CITY OF ALBUQUERQUE

April 22, 2013

**Re: L&C Transport, 8705 Central Avenue NW, Grading and Drainage Plan
Engineer's Stamp date 04-12-2013 (K-09/D037)**

GRADING AND DRAINAGE PLAN
Checked By: ES
Drawn By: H Head & B Montoya

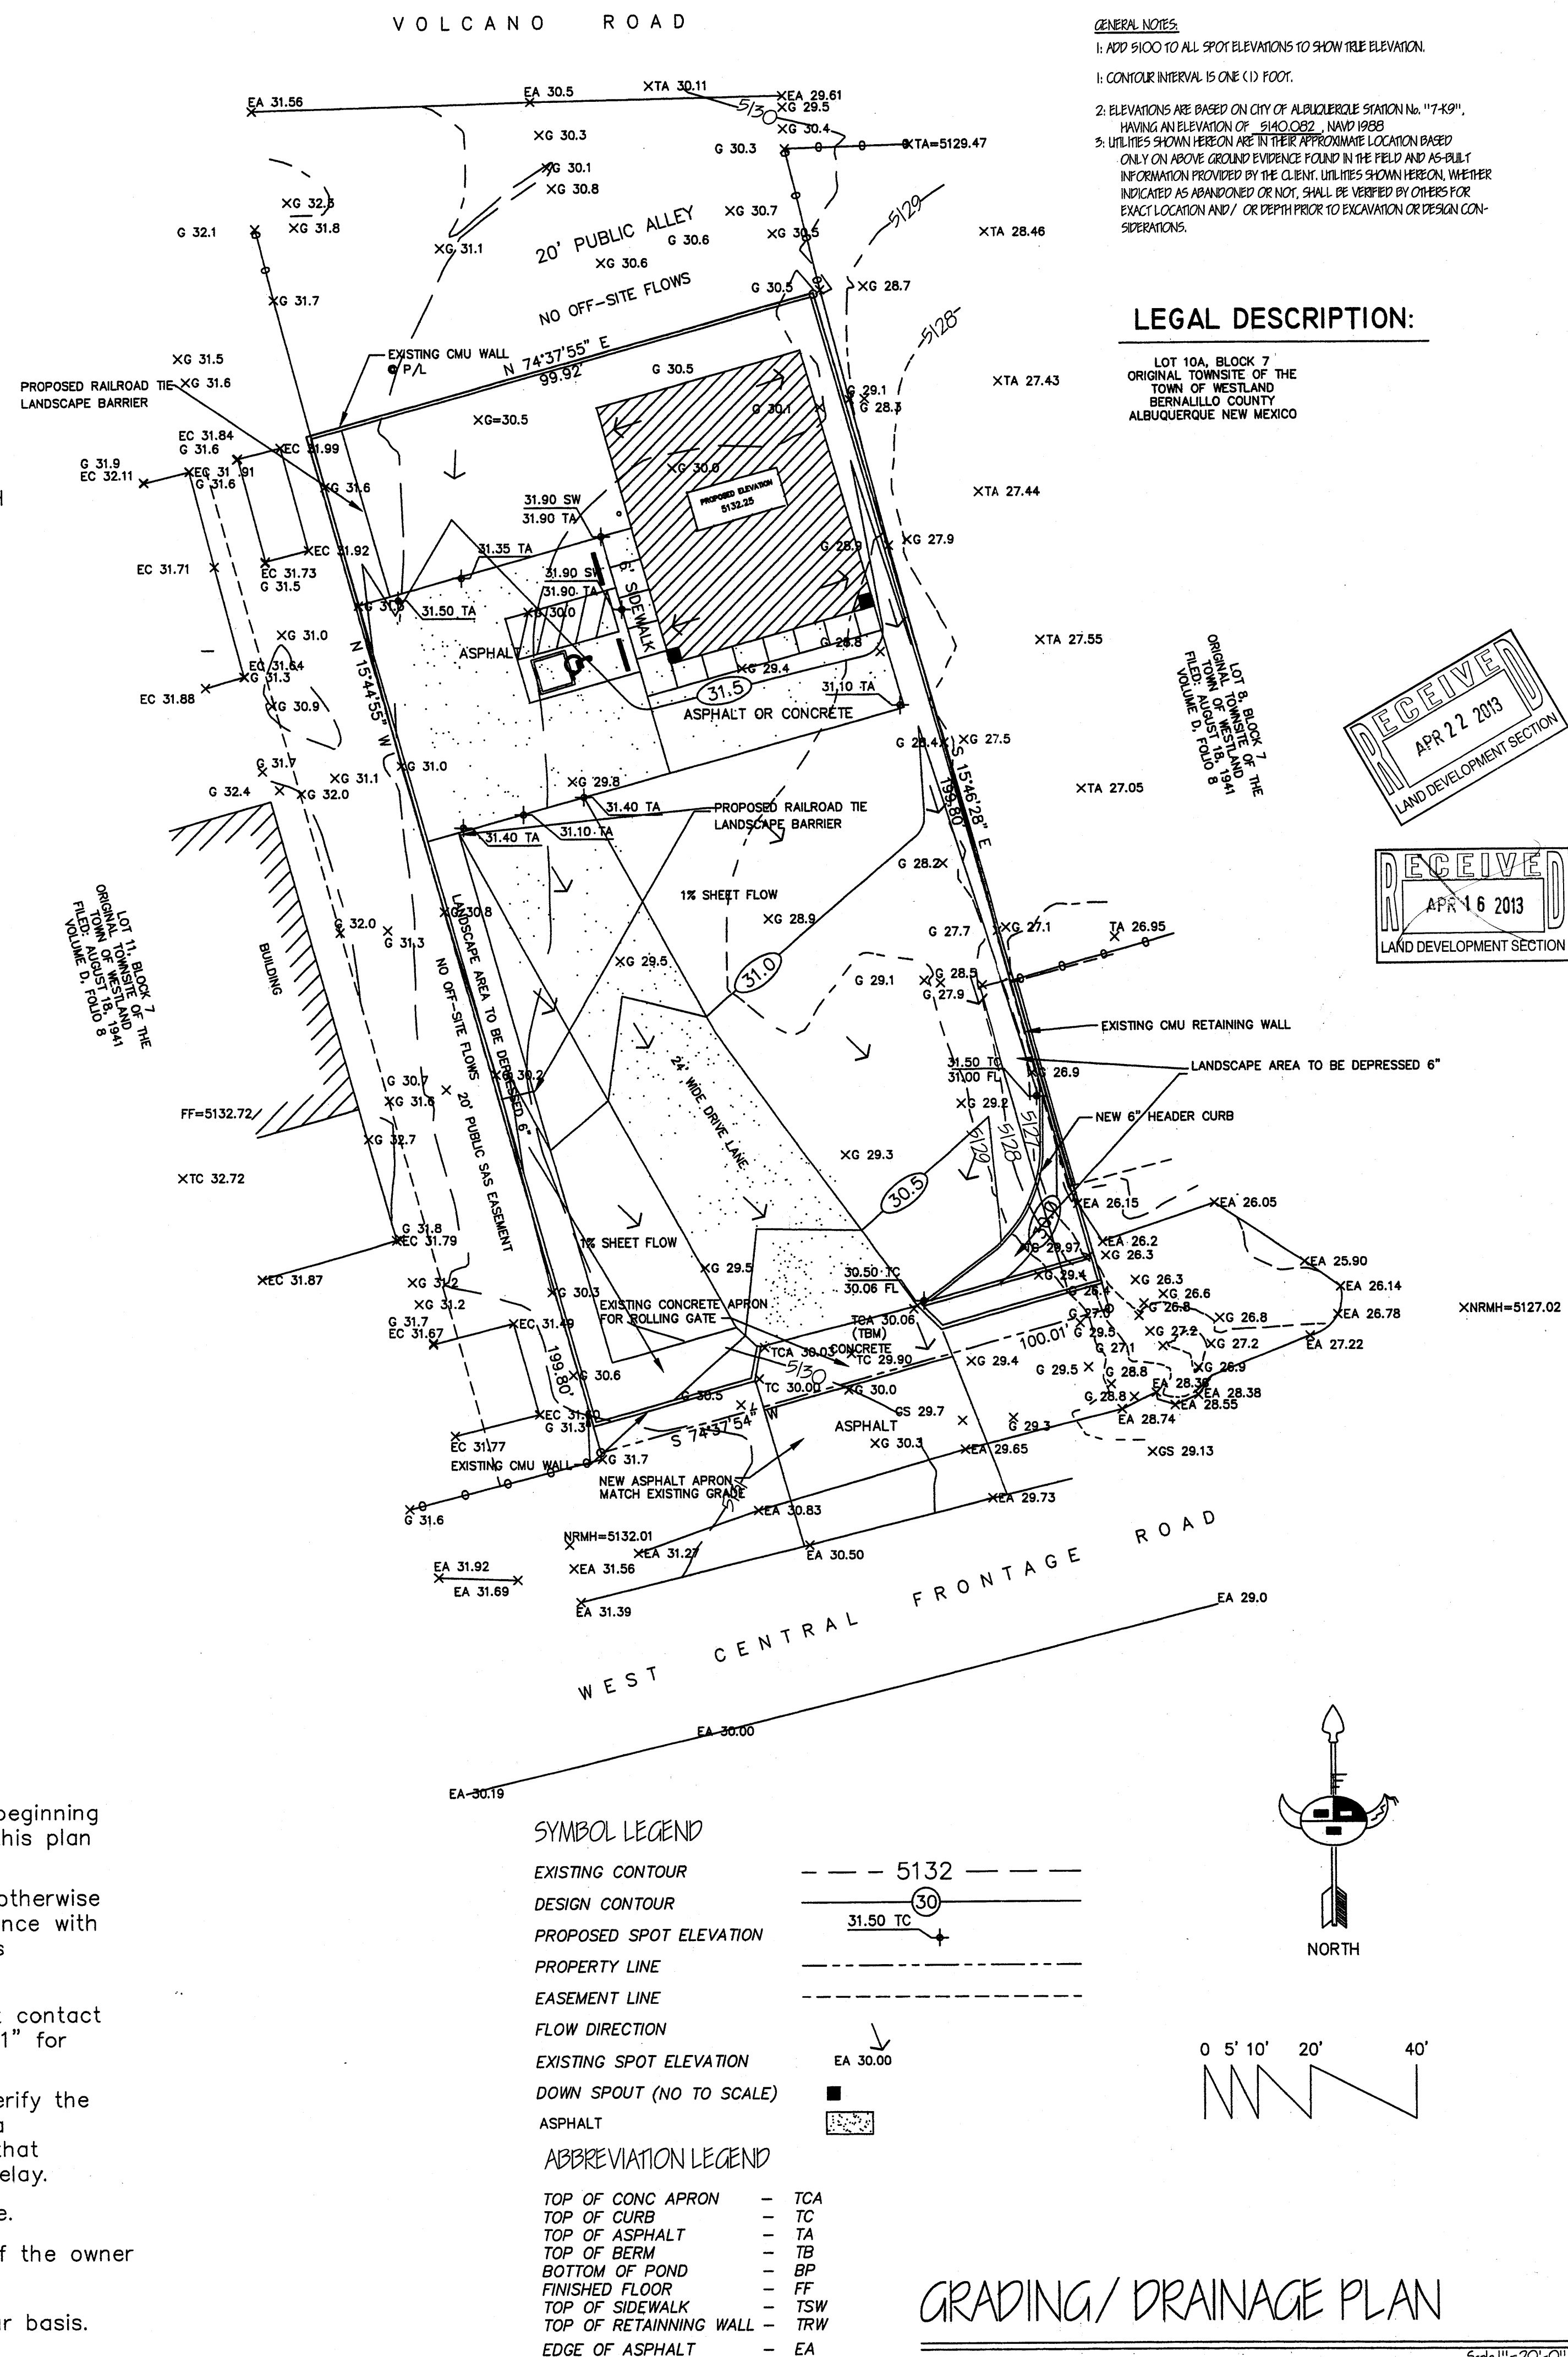
- Provide curb openings along the 6" curb to allow runoff to enter into the landscaping area at the southeast corner of the project.
